# Rezoning Transportation Analysis

Petition Number: 2023-037

Date	Description
7-26-23	First Review (IW)

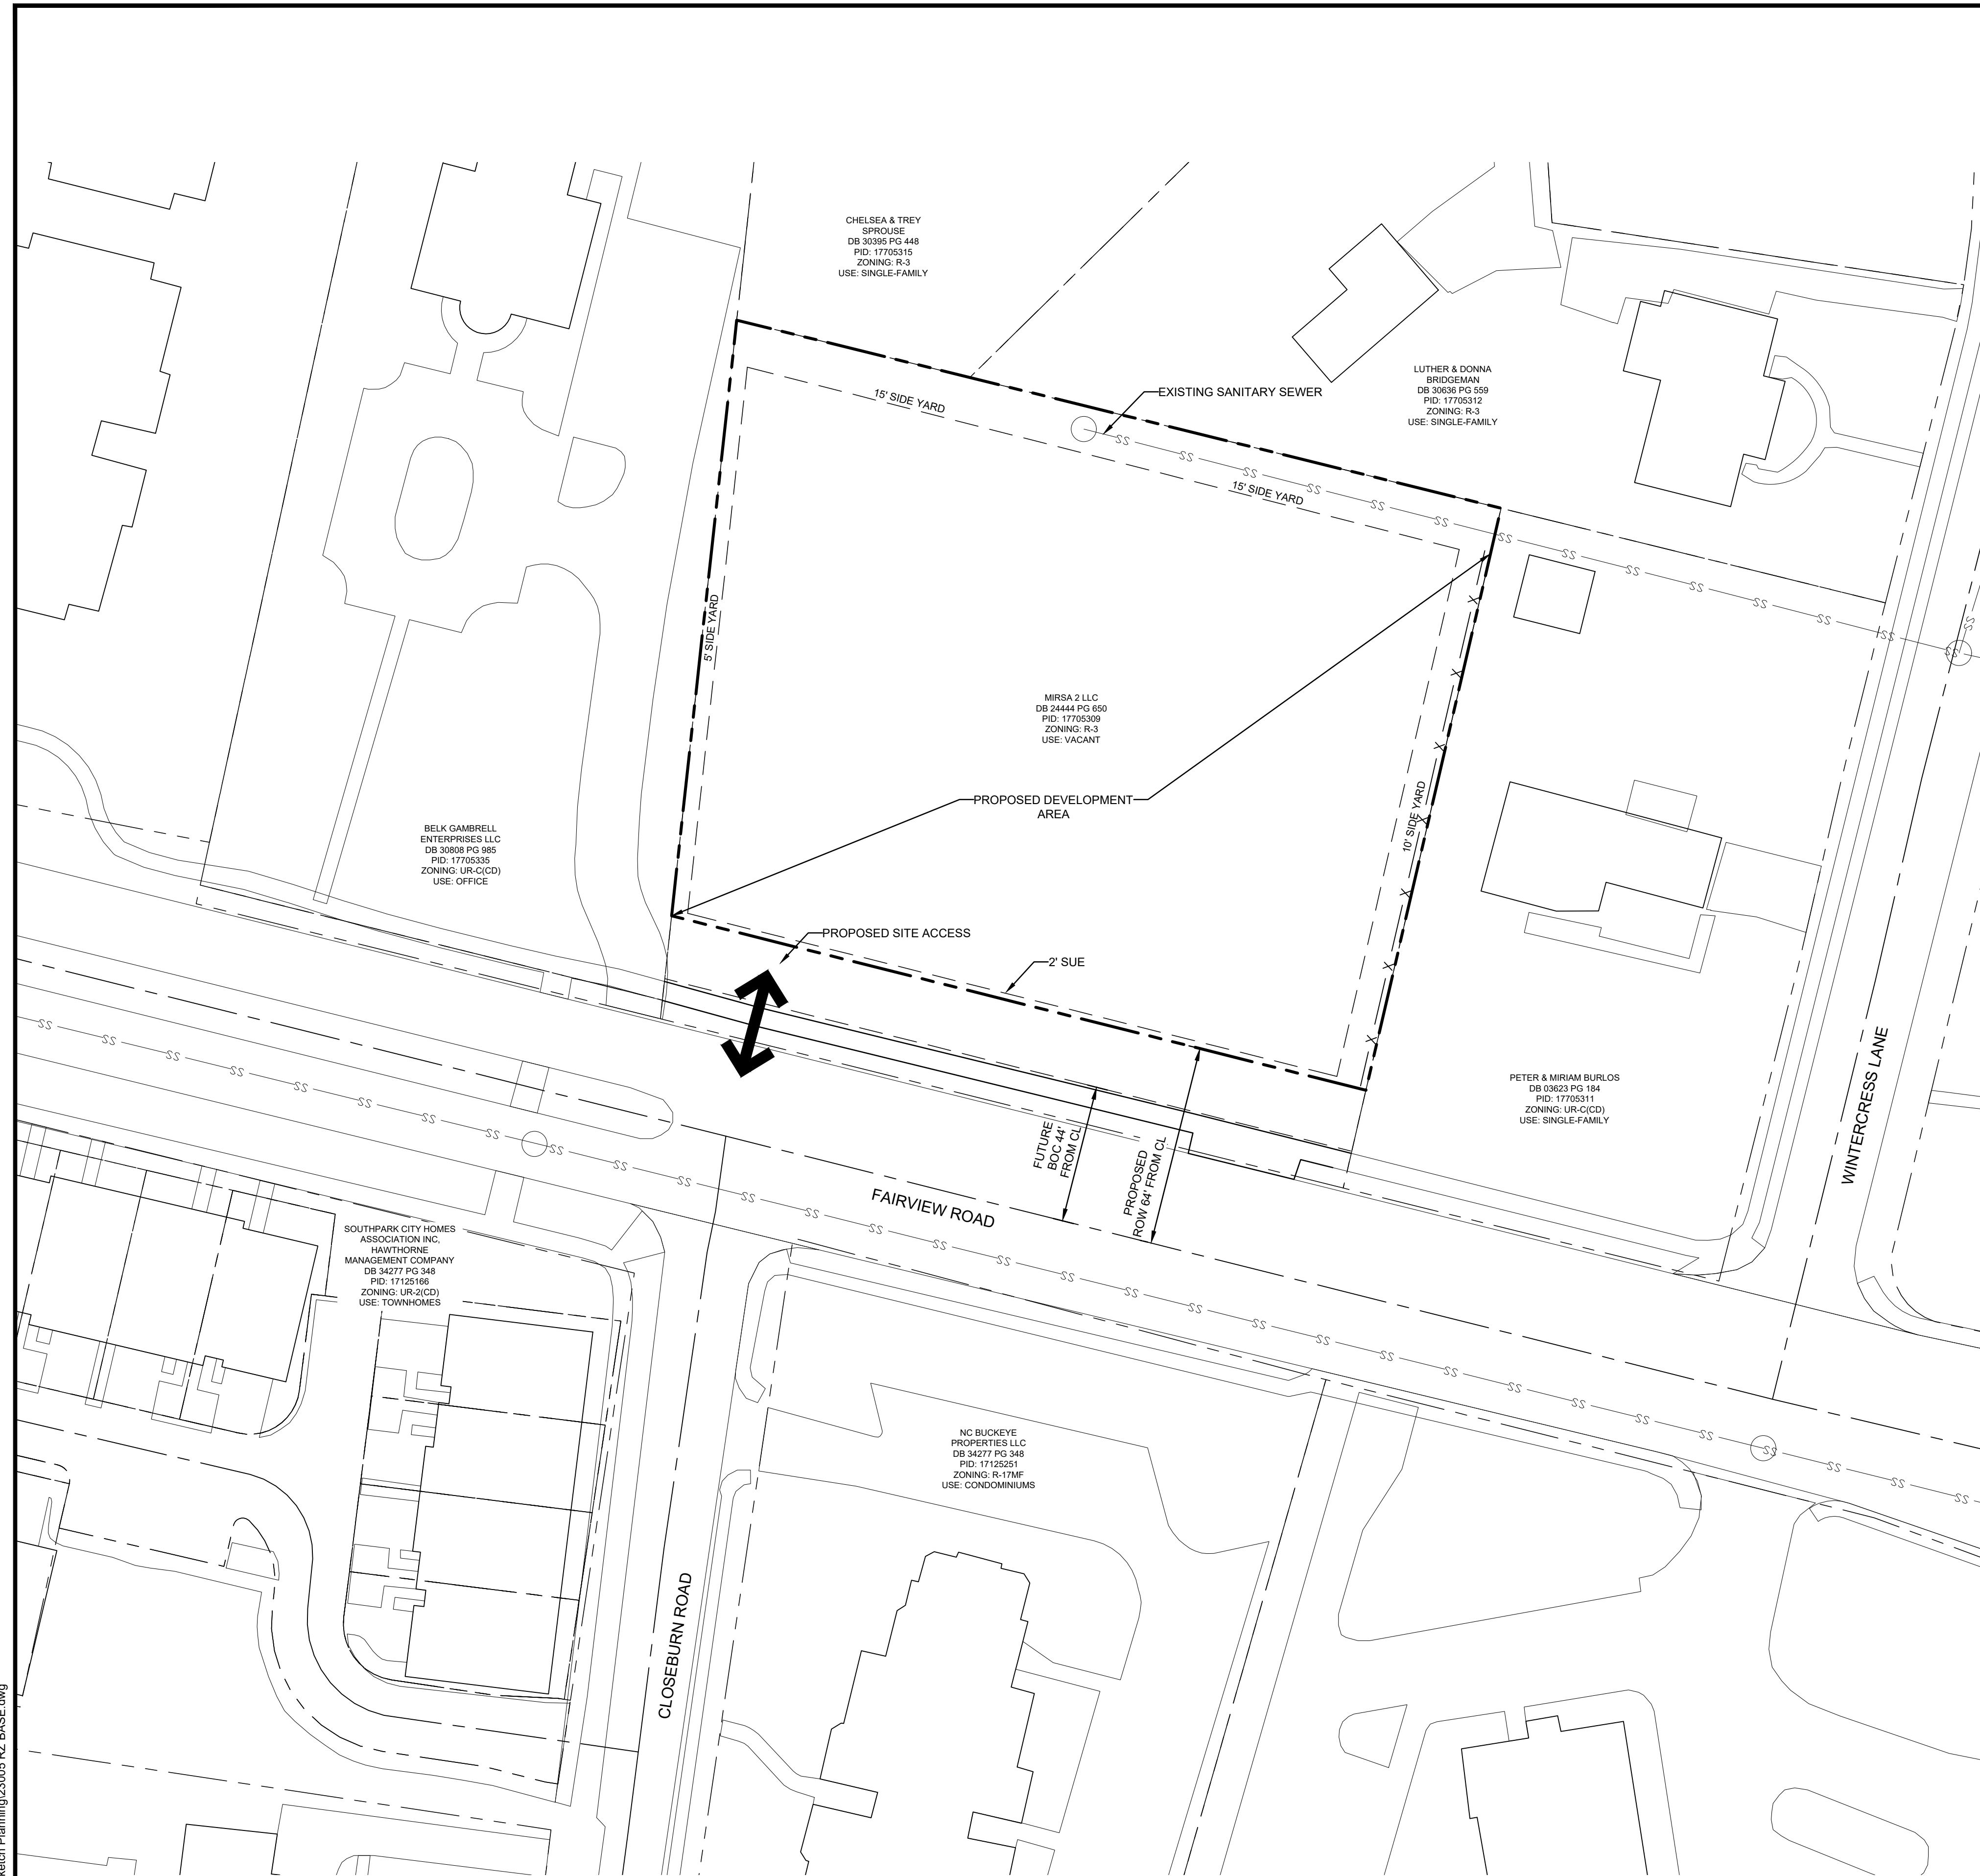
- a. ~~Fairview Road: Show future location of back of curb and gutter to be 44 feet from roadway centerline to accommodate the Charlotte Streets Map with a roadway typical section of [list street components here] OR the future location of curb and gutter is in its existing location.~~

~~NOTE: Additional distance from center line to back of curb may be required in locations where a median is present or around intersections and interchanges.~~

~~Label and dimension the curb and gutter from the centerline for each road on the site plan.~~
